INTAKE COMMENTS RESPONSE LETTER

HONG AND KAO RESIDENCE REMODEL AND DADU

JULY 5, 2023

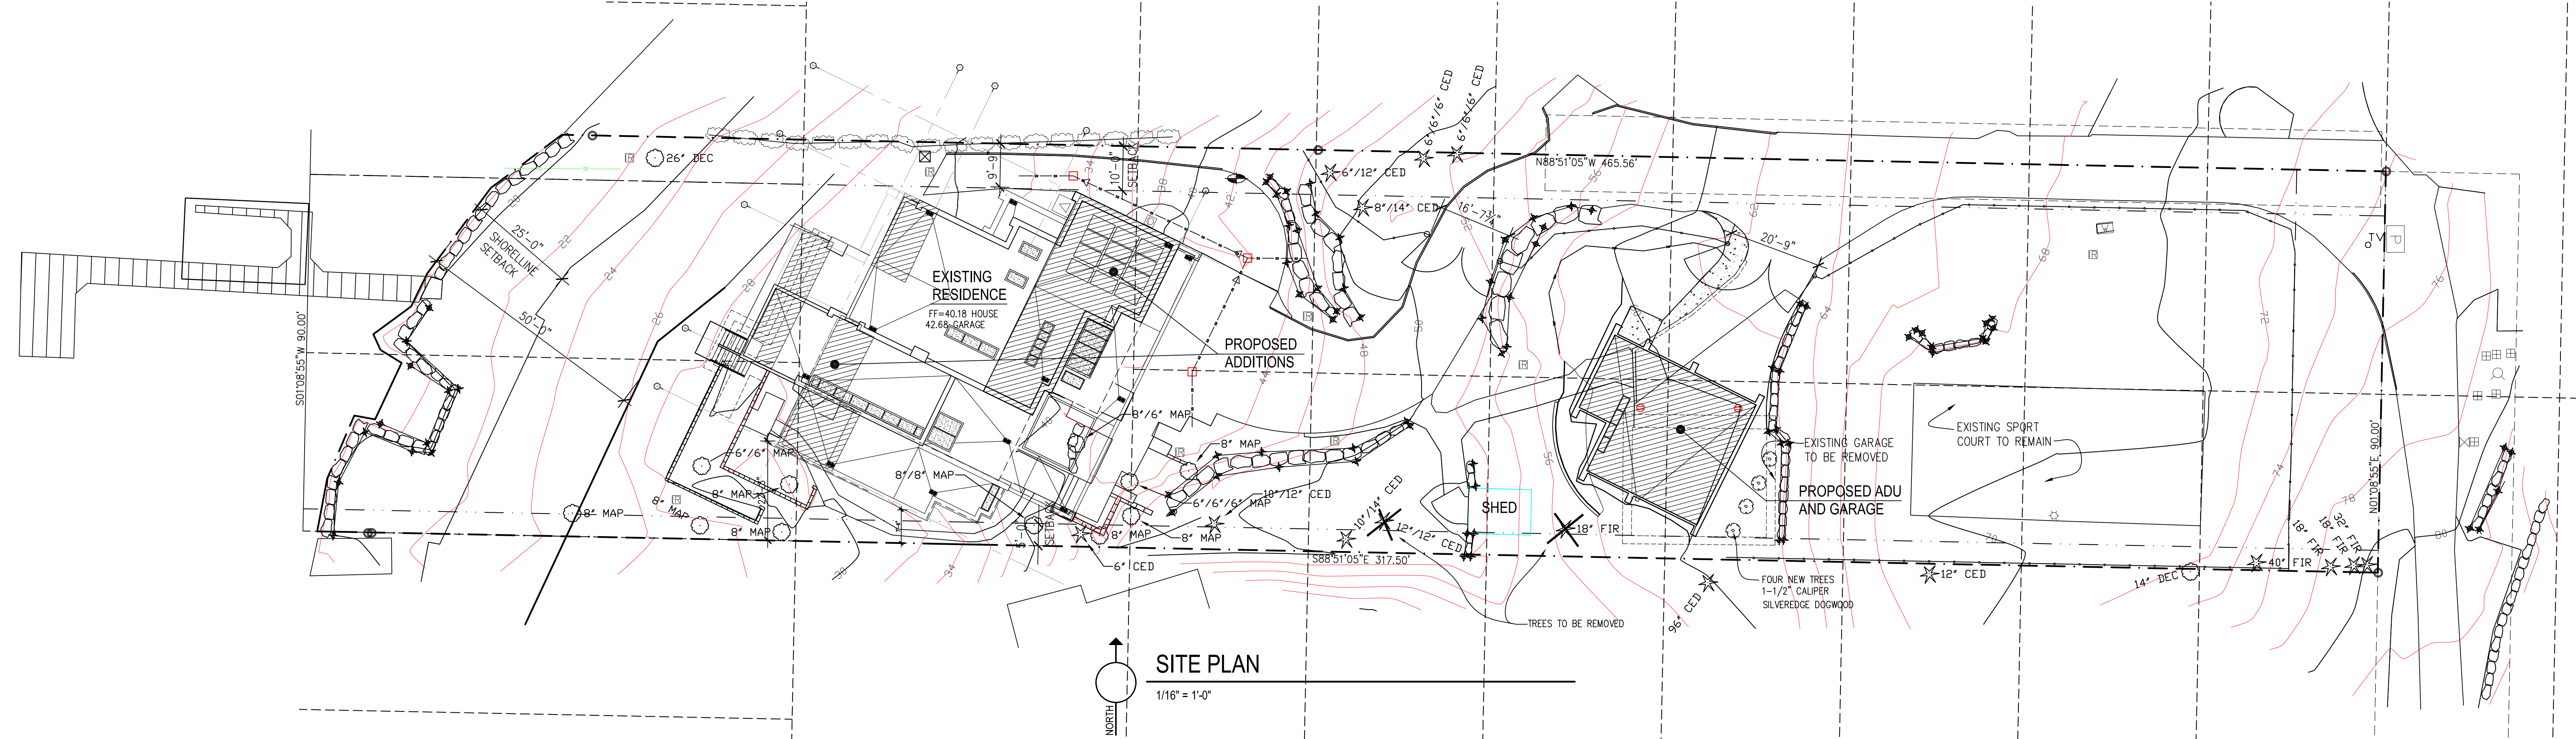
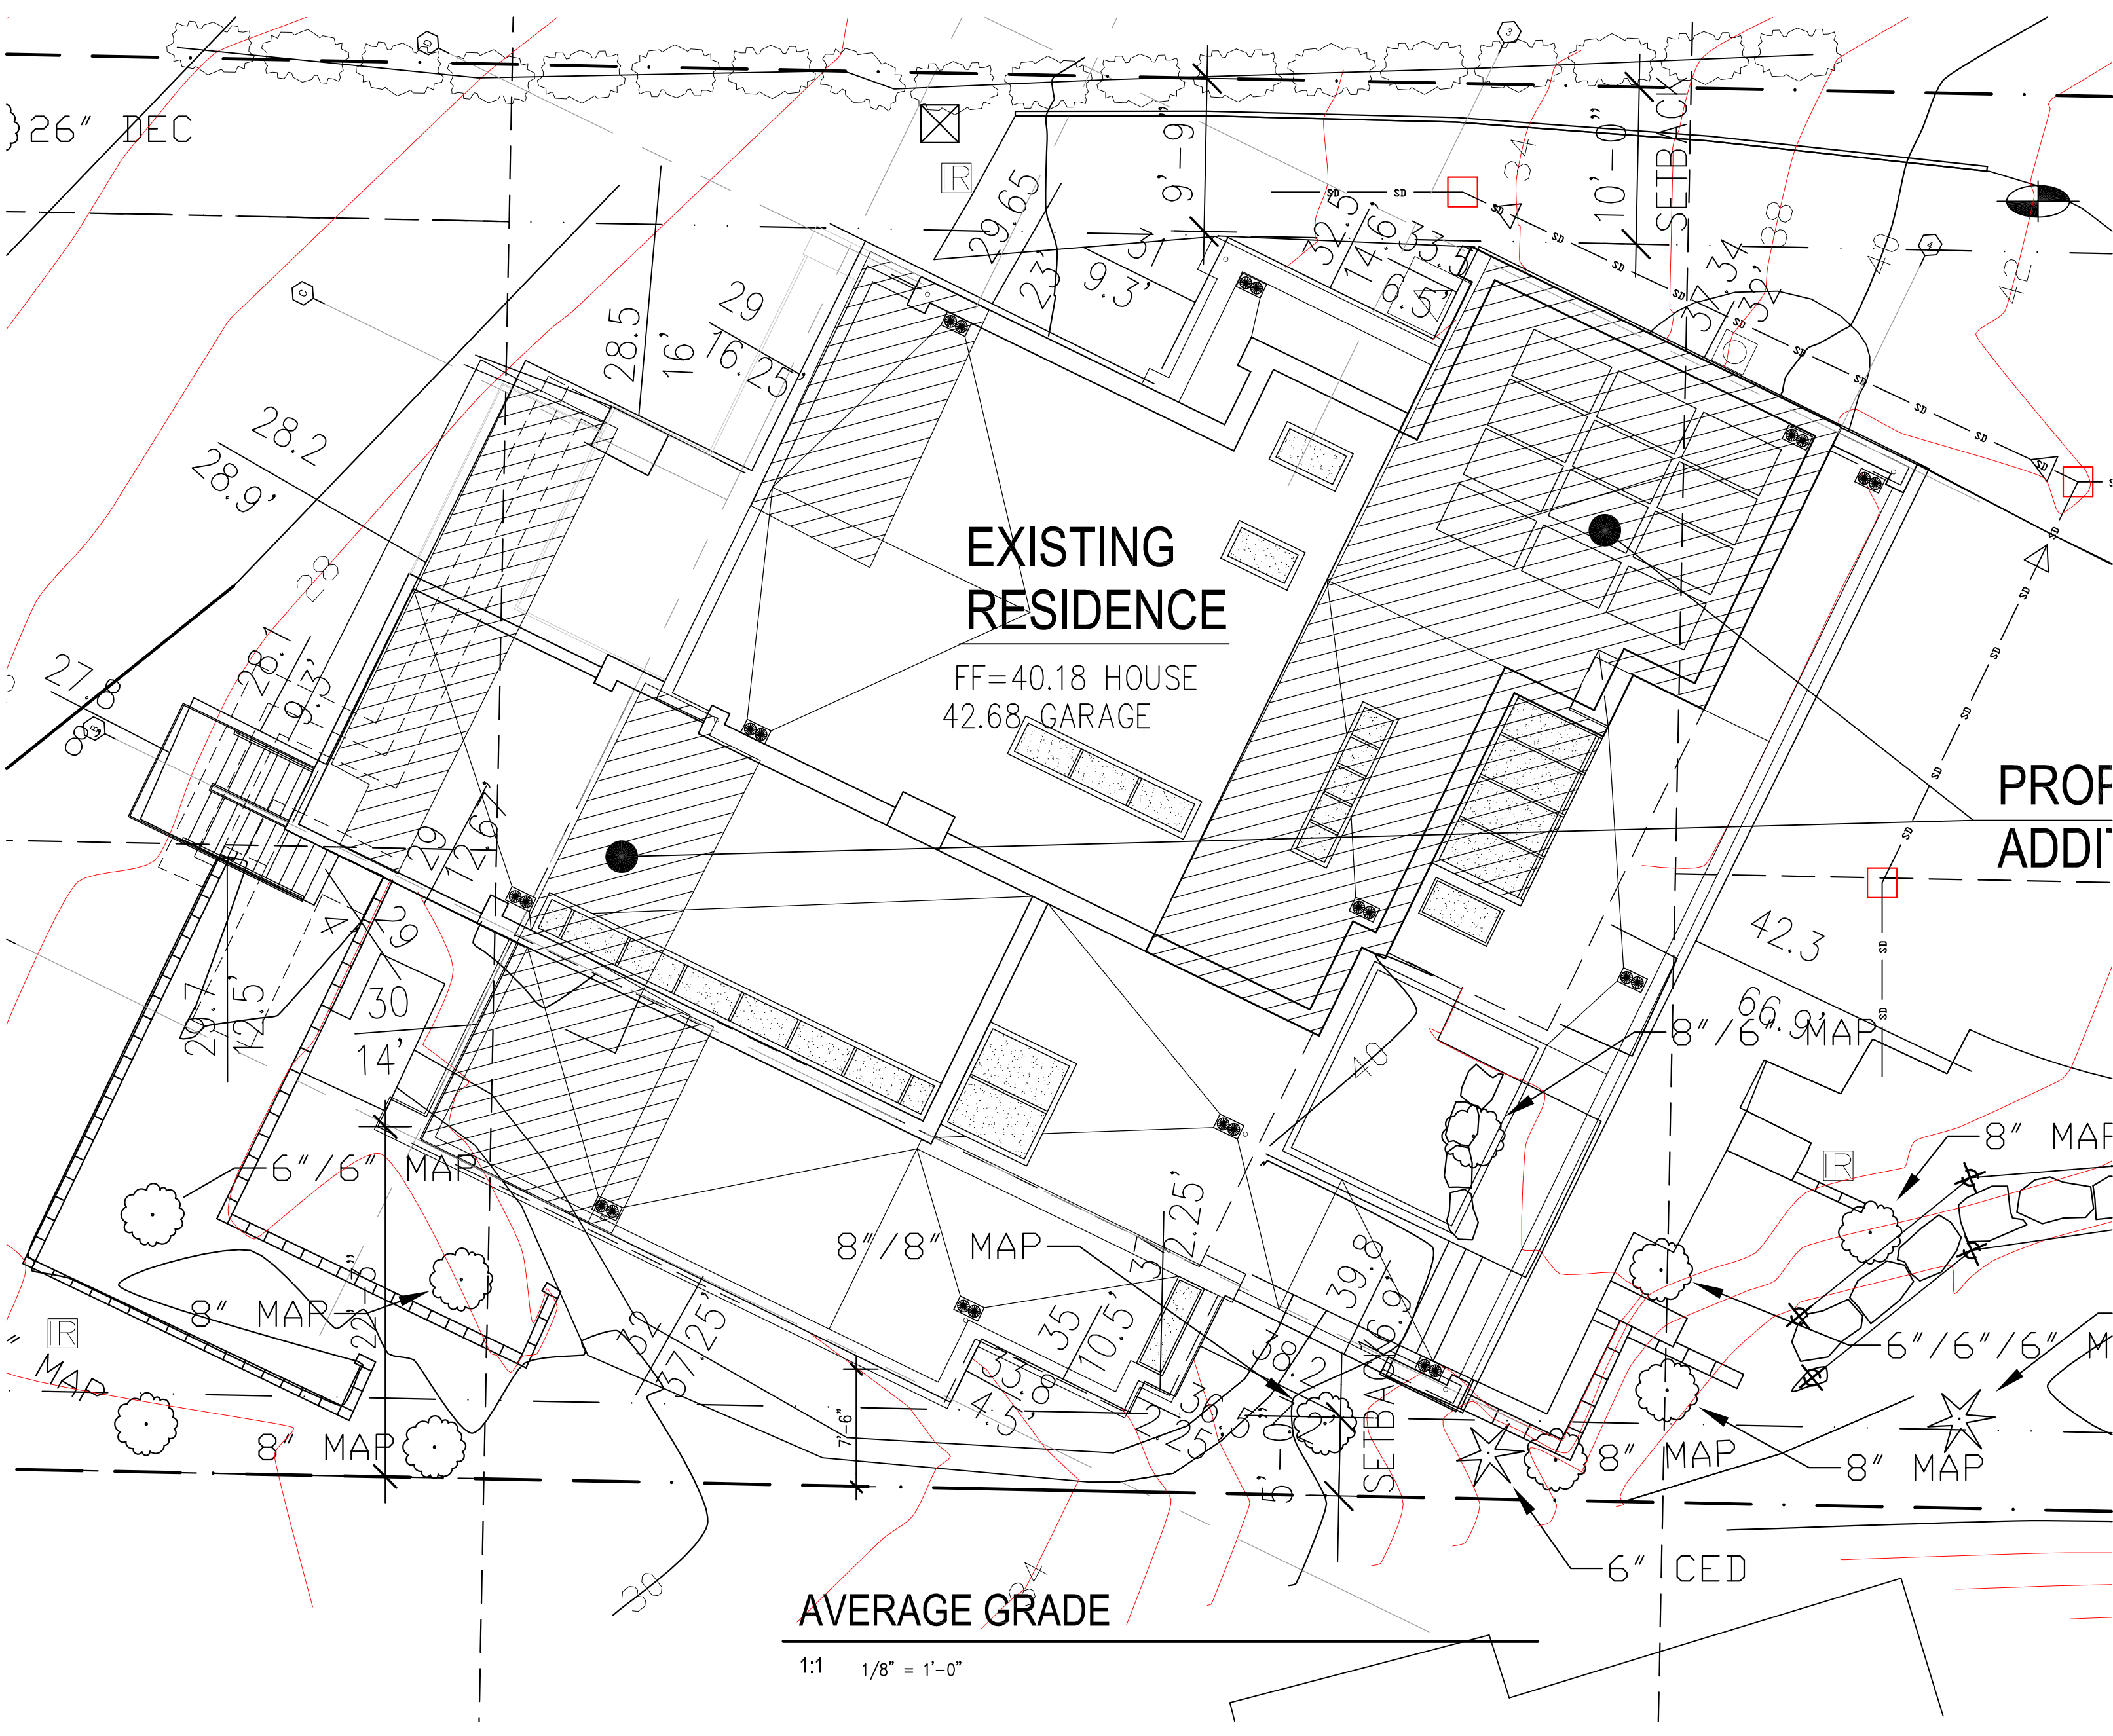
1. Notes regarding fire sprinklers have been added to the drawings
2. A fire code alternative is being requested for the DADU
3. Fire requirements are to be determined

1. RESIDENCE - A note was added to 1.0 requiring an NFPA 14D system
2. DADU – note was added to 1.0
3. CODE – code alternatives are being requested for the DADU

1. A 40% slope area is shown on 1.0, most of the slope is on the neighbor's property and no work is planned in the vicinity.
2. A planting plan is being prepared and will be submitted as deferred submittal
3. A critical areas II review is being applied for

NORTH ELEVATION

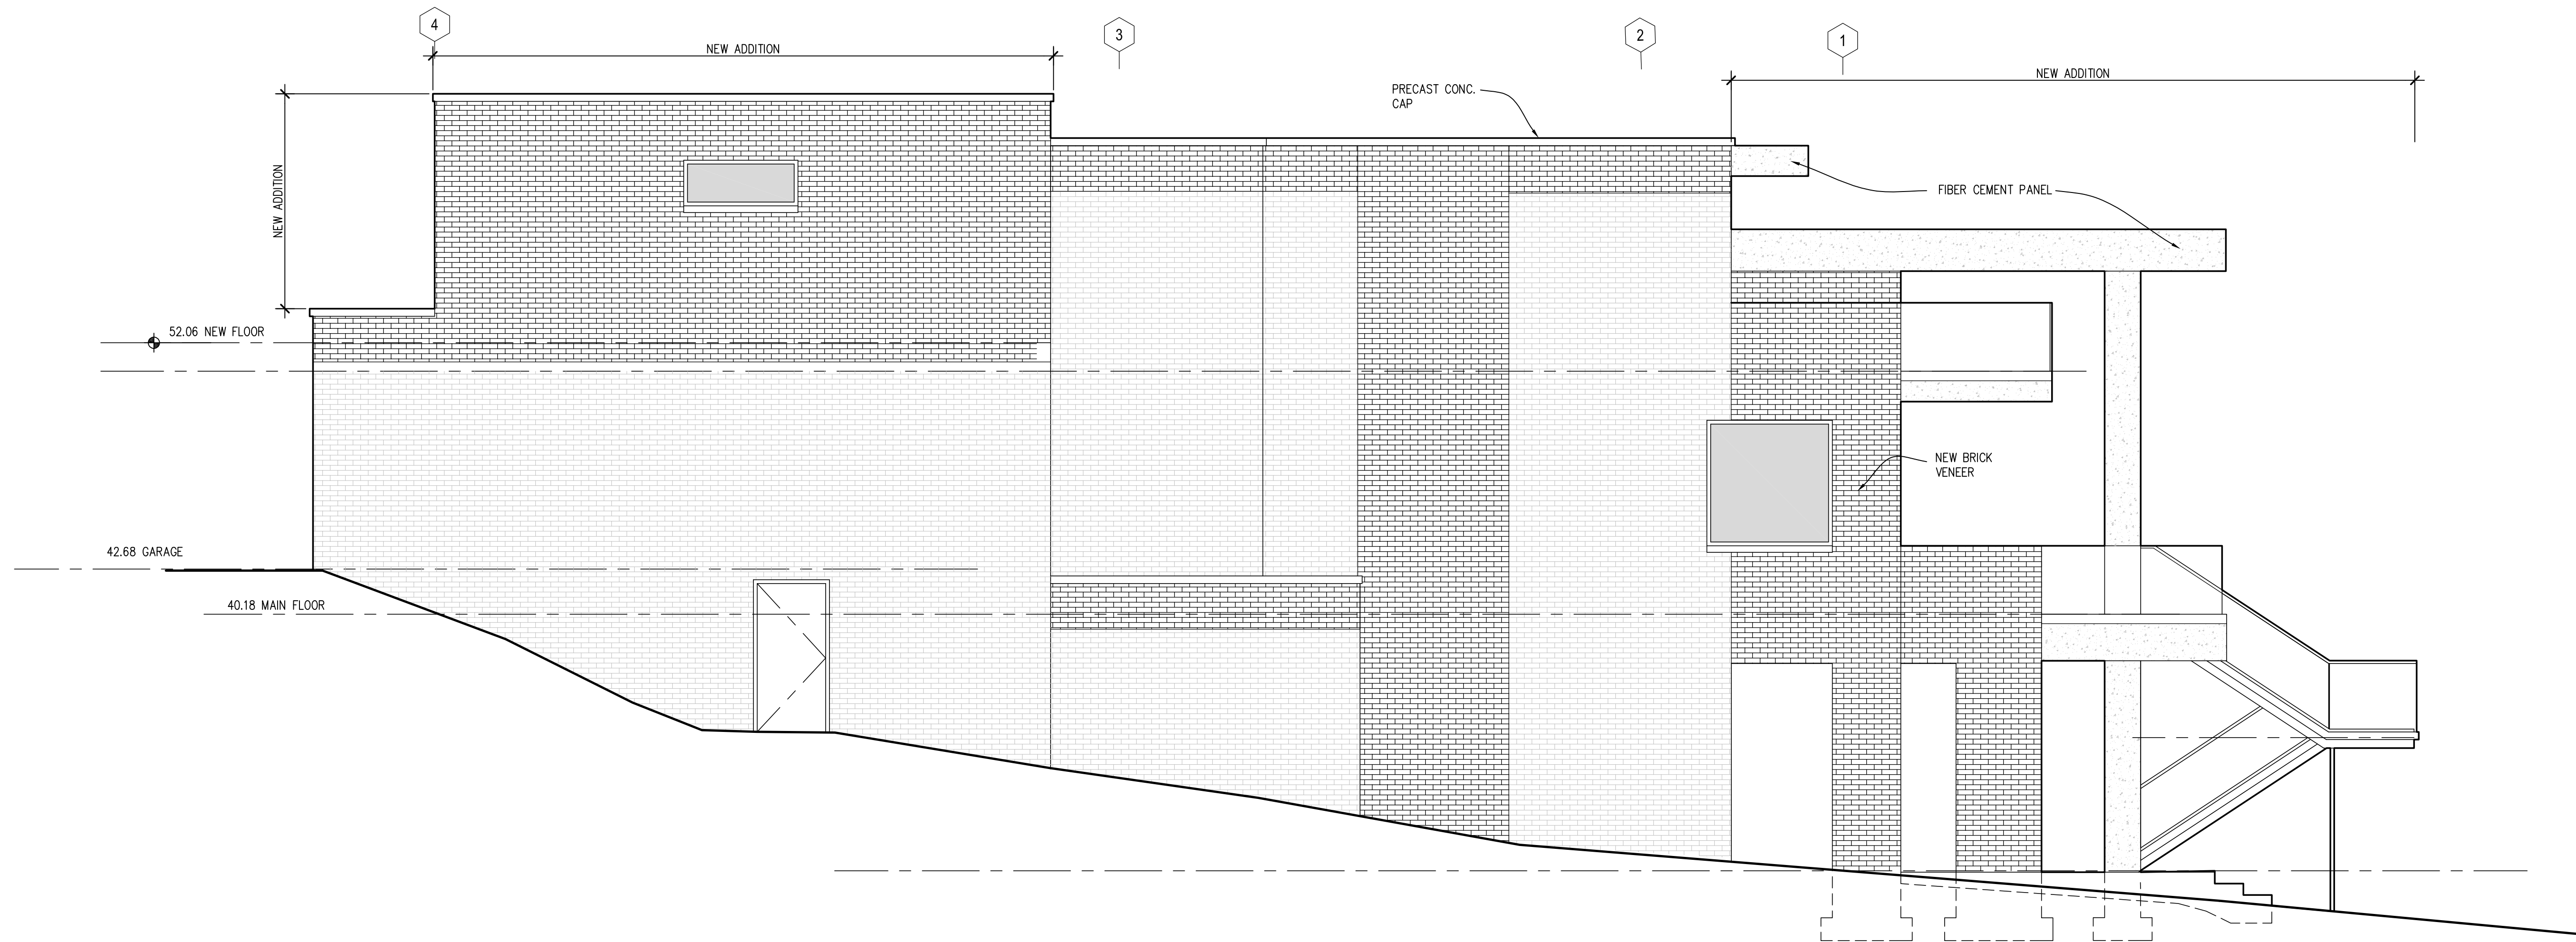
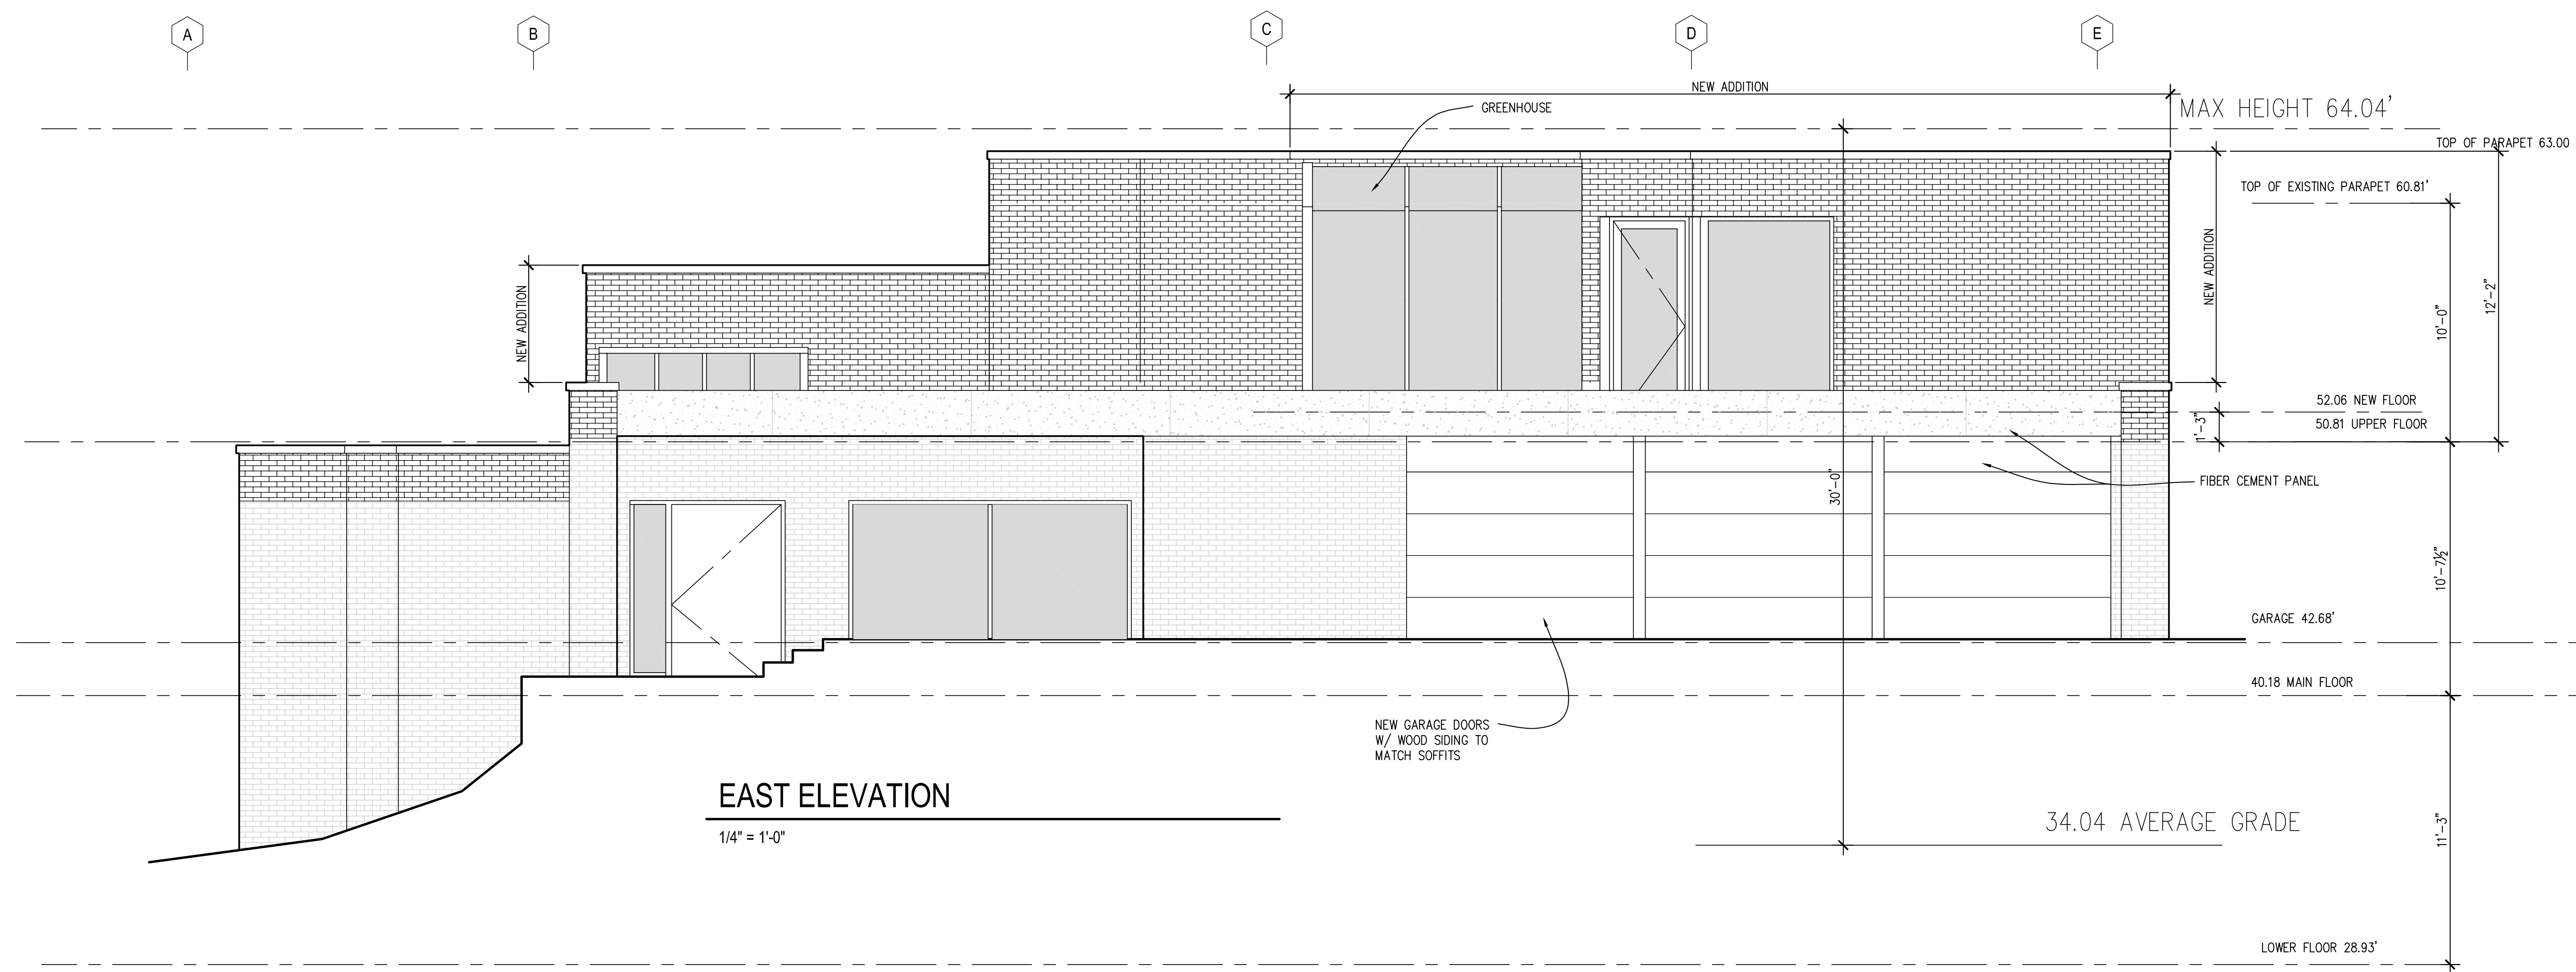
4. The maximum downhill façade height is shown on 5.0. The existing height is non-conforming and no increase is proposed

1. A separate critical area review 2 application is now included along with attachments
2. The height of the existing roof is shown on 5.0. The existing height is non-conforming and no increase is proposed
3. Downhill façade height is shown on 5.0
